PO BOX 271, EPPING 1710

New Epping South Public School - SSD-8873789

LANDSCAPE MASTERPLAN

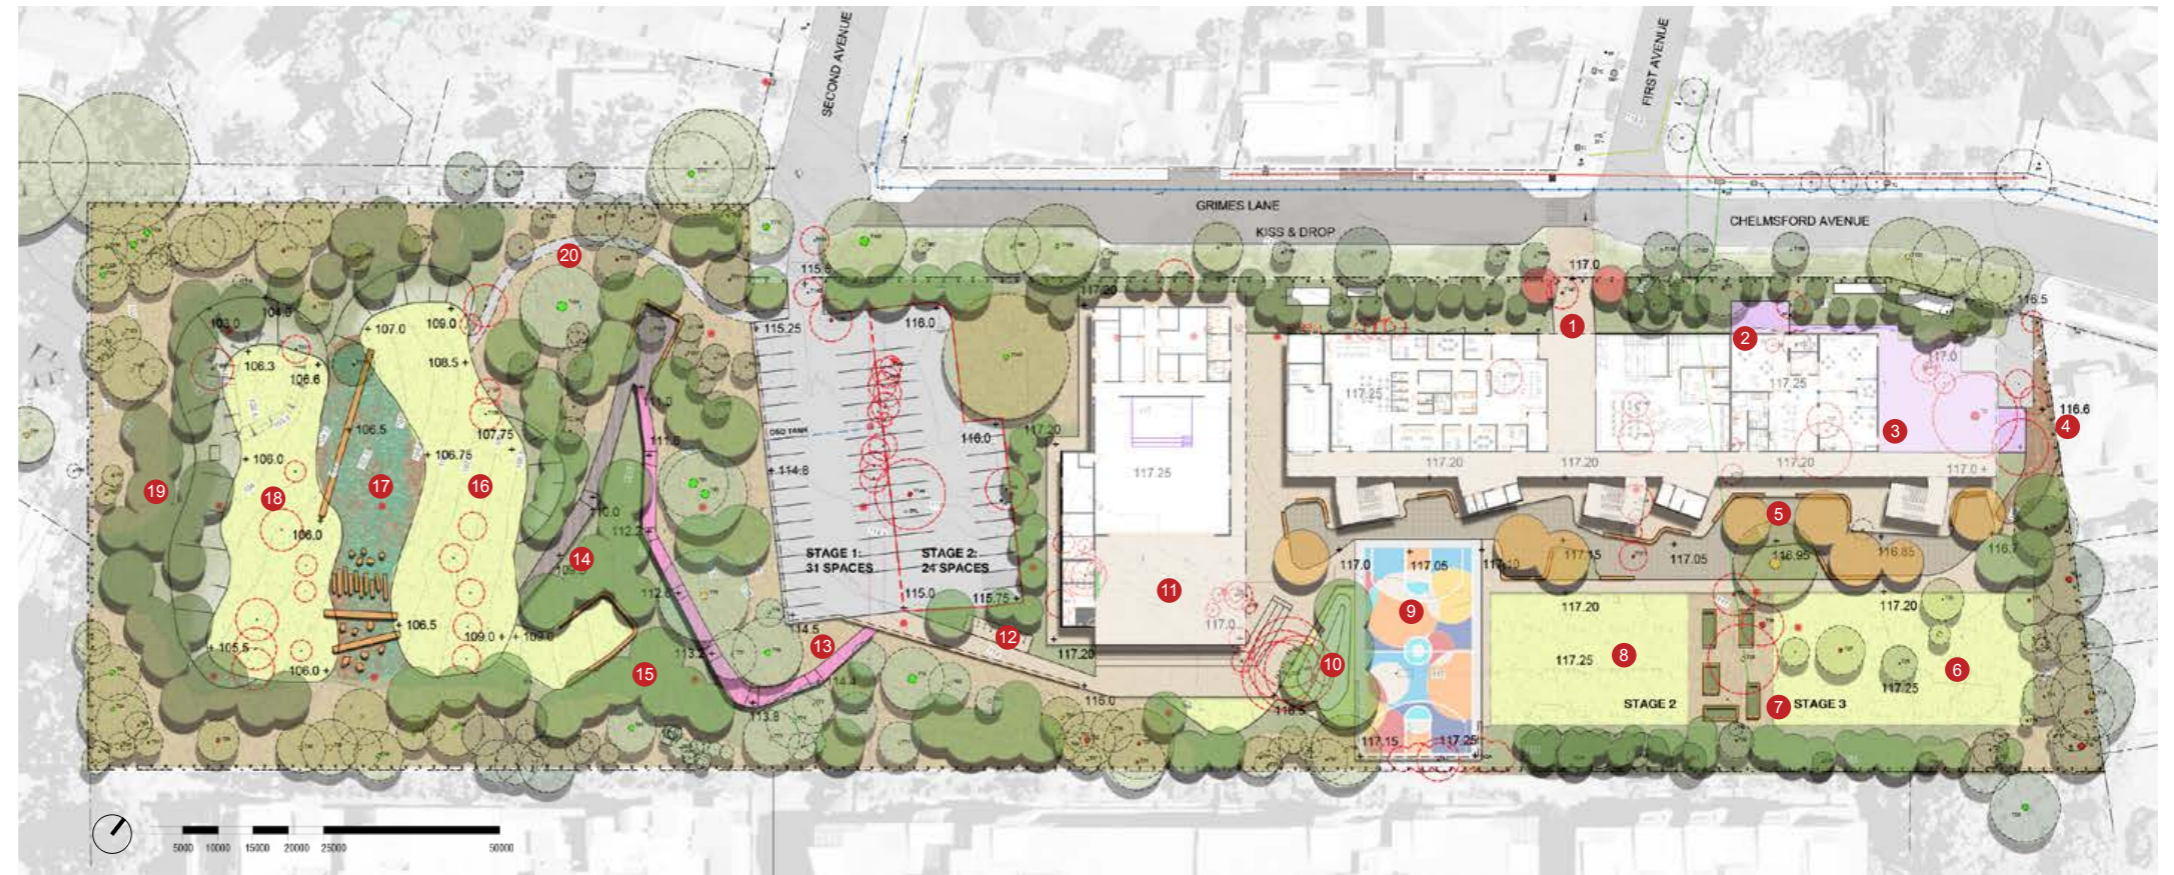
b) Playground space: The plans outline for Home Bases Stage 2 and 3 shows that these future built classrooms will be located on the southern boundary. This will remove most playground space at the eastern end of the site. Where are over 1,000 children going to play?

The outdoor play area in the sensitive western end of the site may offer a unique environmental experience for the students of this school, but it doesn't come without risk. The condition of the key trees will need ongoing monitoring to ensure their root zones are not damaged by foot traffic, and any regular pruning should aim to balance necessary management with the preservation of these key specimens for future generations.

Figure 7-2: Transport Layout

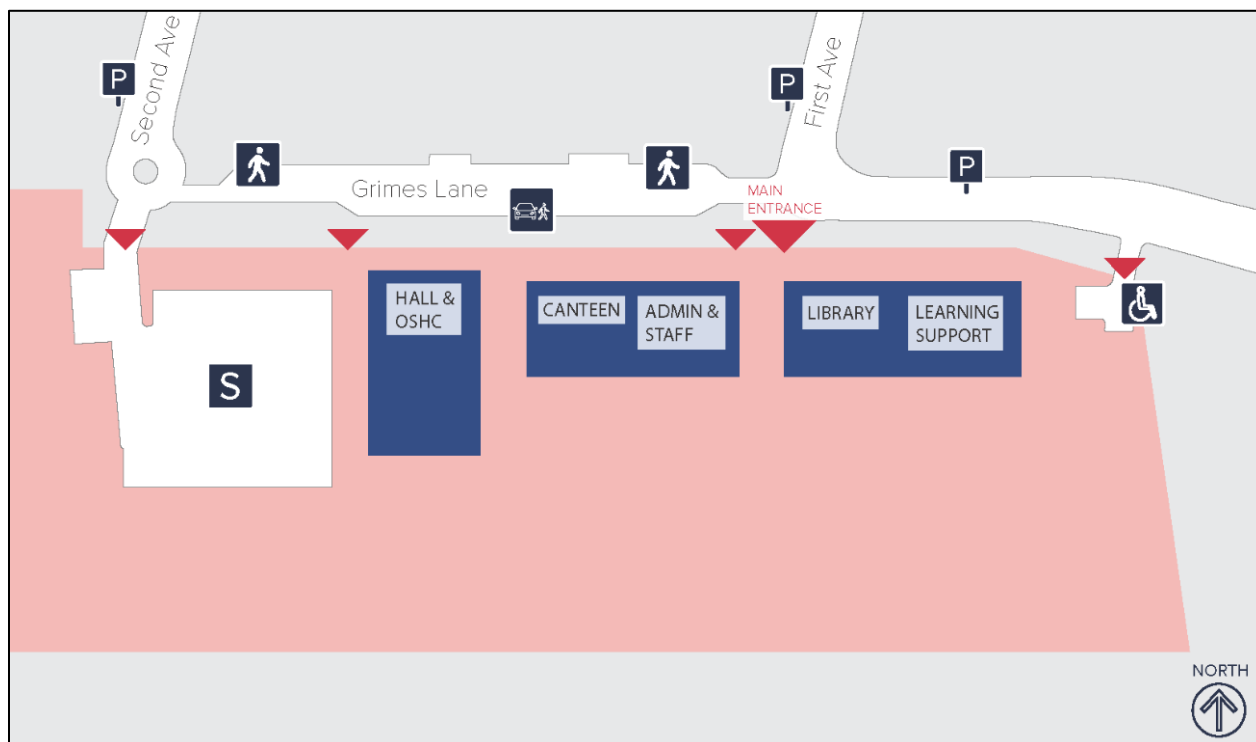
a) Kiss and Drop Zone

It is noted that this zone will only accommodate about half the desired usage in the drop off peak times. Extending the area was rejected because it would require

removal of significant trees (and the Trust supports their retention). But no alternative options seem to have been modelled in the Transport Access Impact Assessment. Instead, the issue is just ignored as if it won't actually happen. This is not satisfactory at all and will have a very detrimental impact on local residents through increased numbers of parents parking nearby, and having to exit their cars and walk over to the school to collect their children.

Recommendation: A superior Kiss and Drop zone is absolutely key to the traffic flow (and reducing impacts on local residents). This aspect needs reassessment and alternative options explored.
